Kirklees Council - Planning
Investment and Regeneration Service
PO Box B93, Civic Centre 3,
Off Market Street,
Huddersfield HD1 2JR
30 November 2020

Objection to Planning Application 2020/93467, 402 Birkby Road, Huddersfield

CLIENT:	
ACUMEN	
JOB TITLE:	
GATEPOSTS AT 402 BIRKBY ROAD, HUDDERSFIELD	
DRAWING TITLE:	
PROPOSED SITE PLAN & ELEVATION	
DRAWN: JF	DATE: Sep
CHECKED: JC	SCALE: 1:200 @ A1
DRAWING NUMBER:	2532 - 12

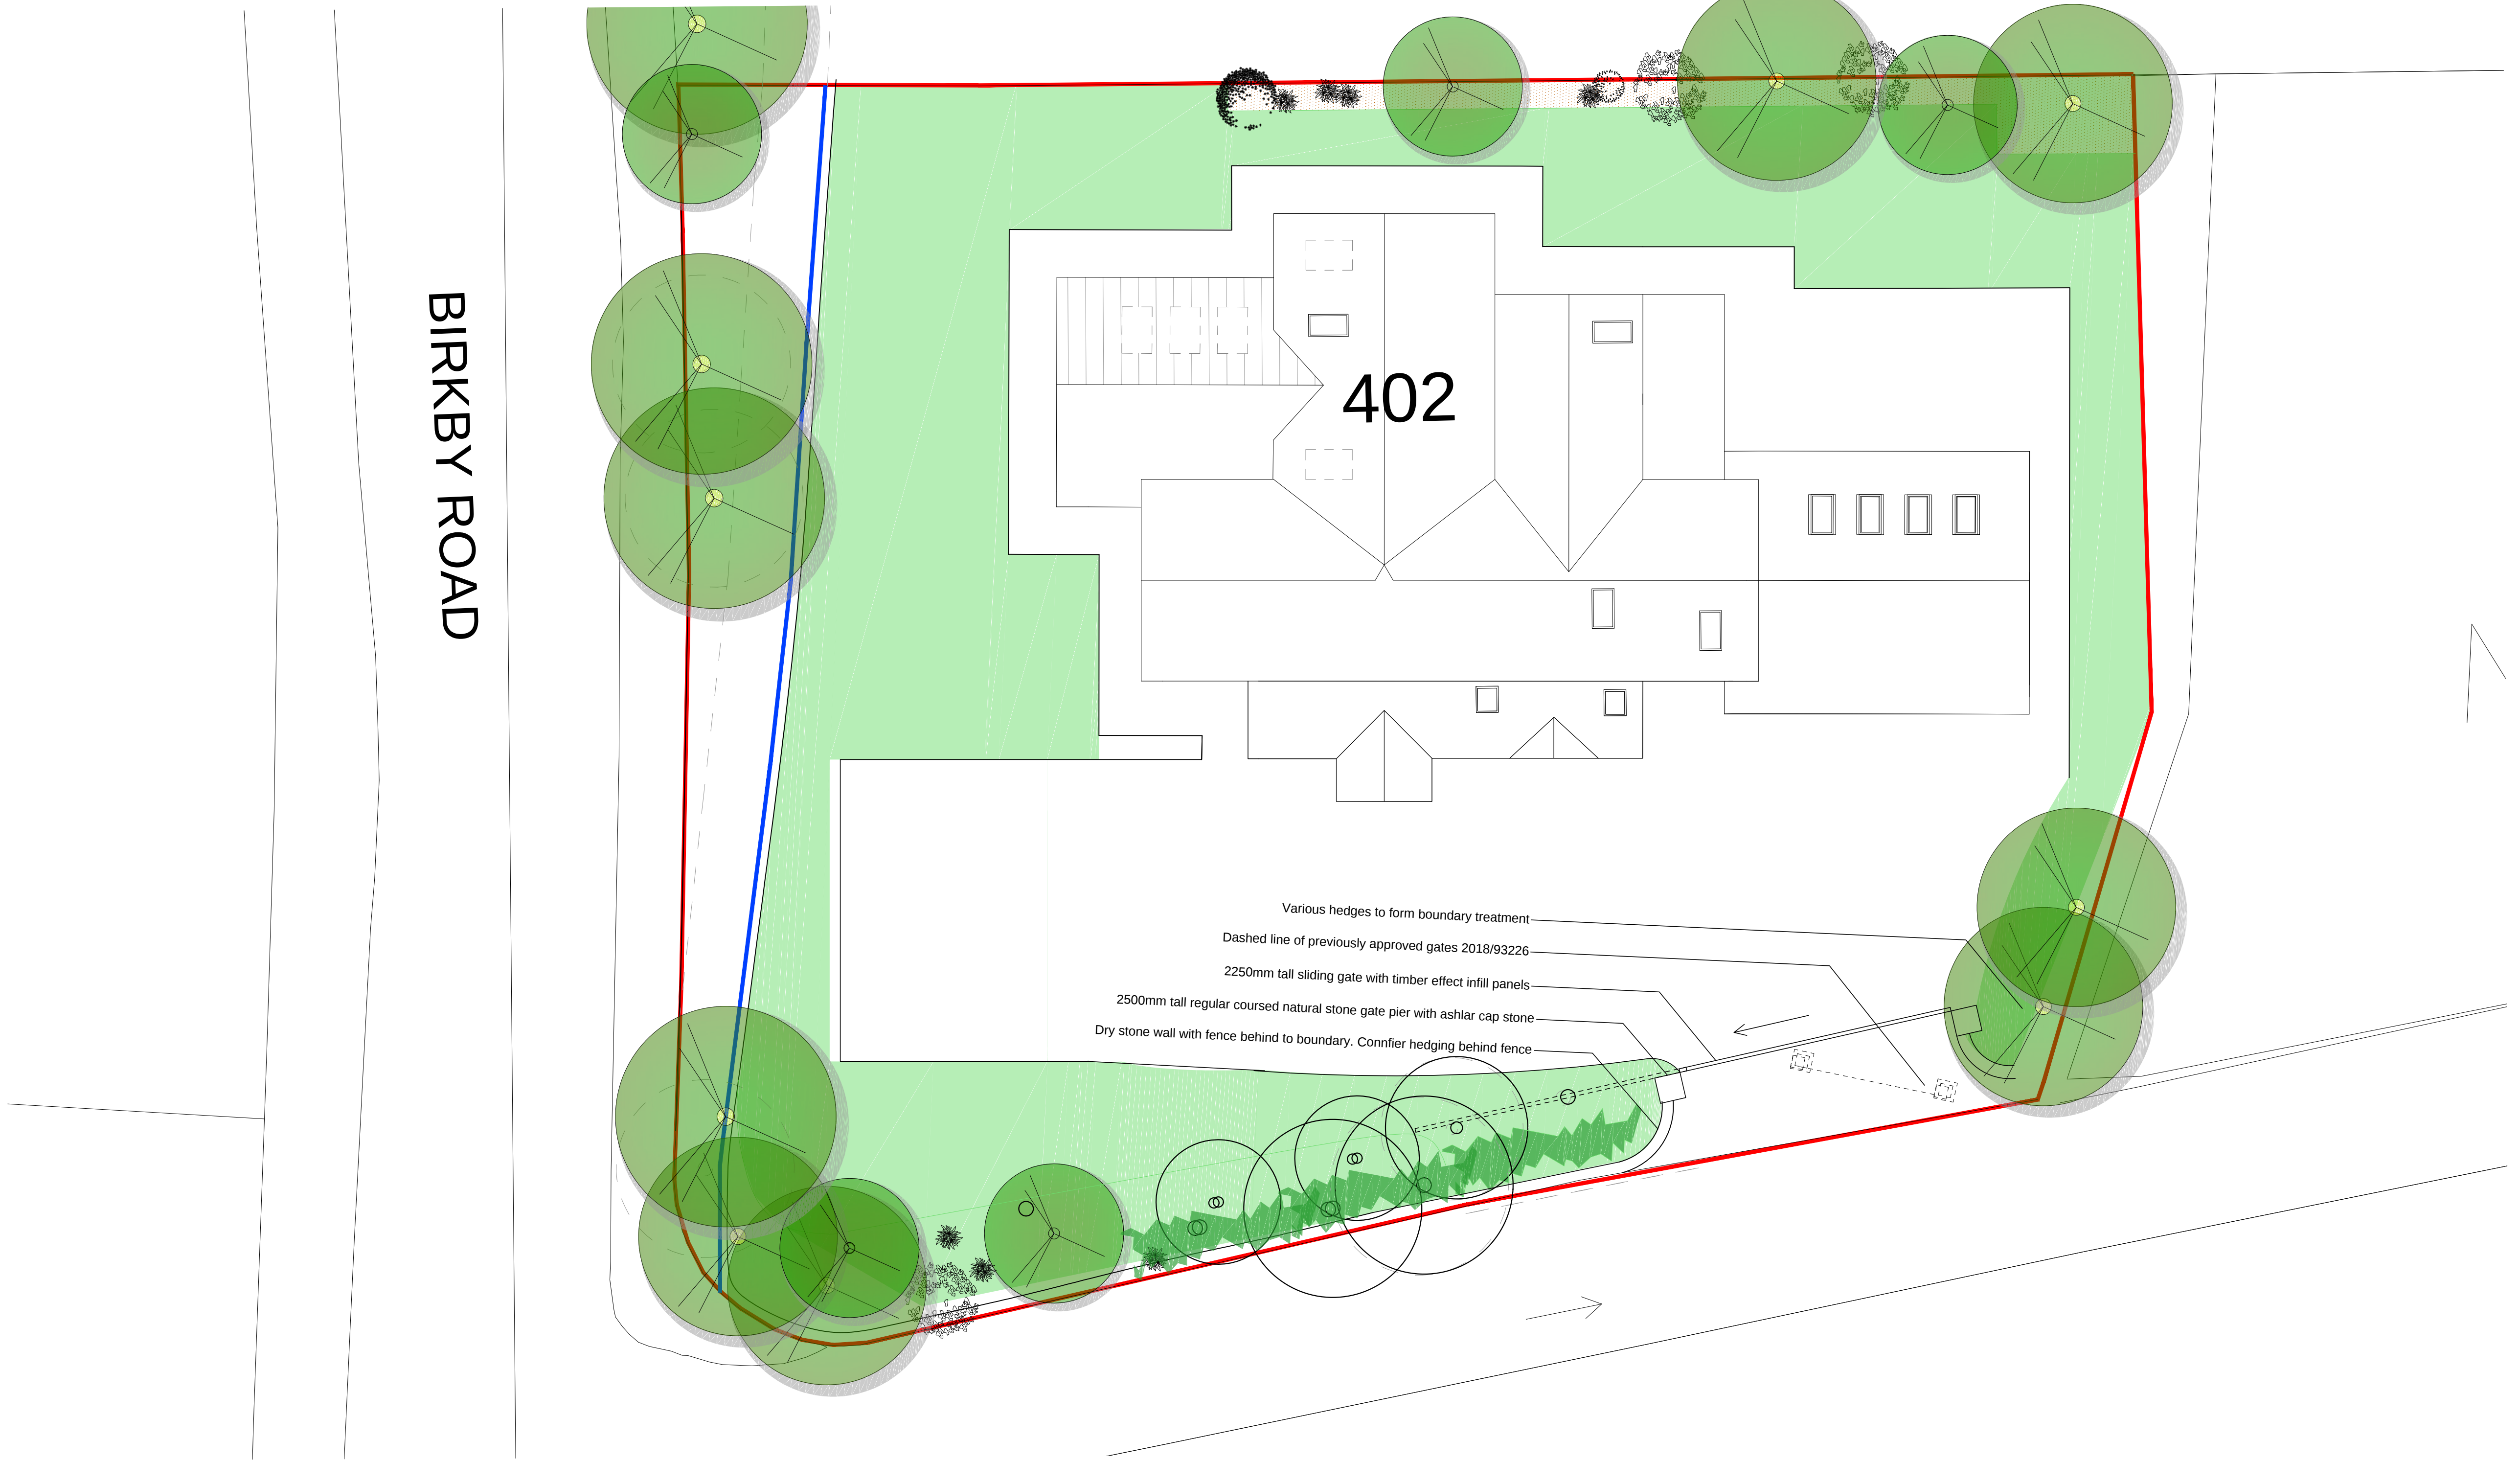
Since it is a highway, any fence, gate or gatepost can only be a maximum of 1 metre above ground level without planning permission. At 2 metres, 2.25 metres and 2.5 metres respectively, the fence, gate and gateposts exceed the limit considerably. The effect of this is an overbearing appearance along the lane which is particularly exacerbated by the massive gate; not only its height, but also its length which at 7 metres is not suitable or necessary for a domestic property. It is the width of 3 cars.
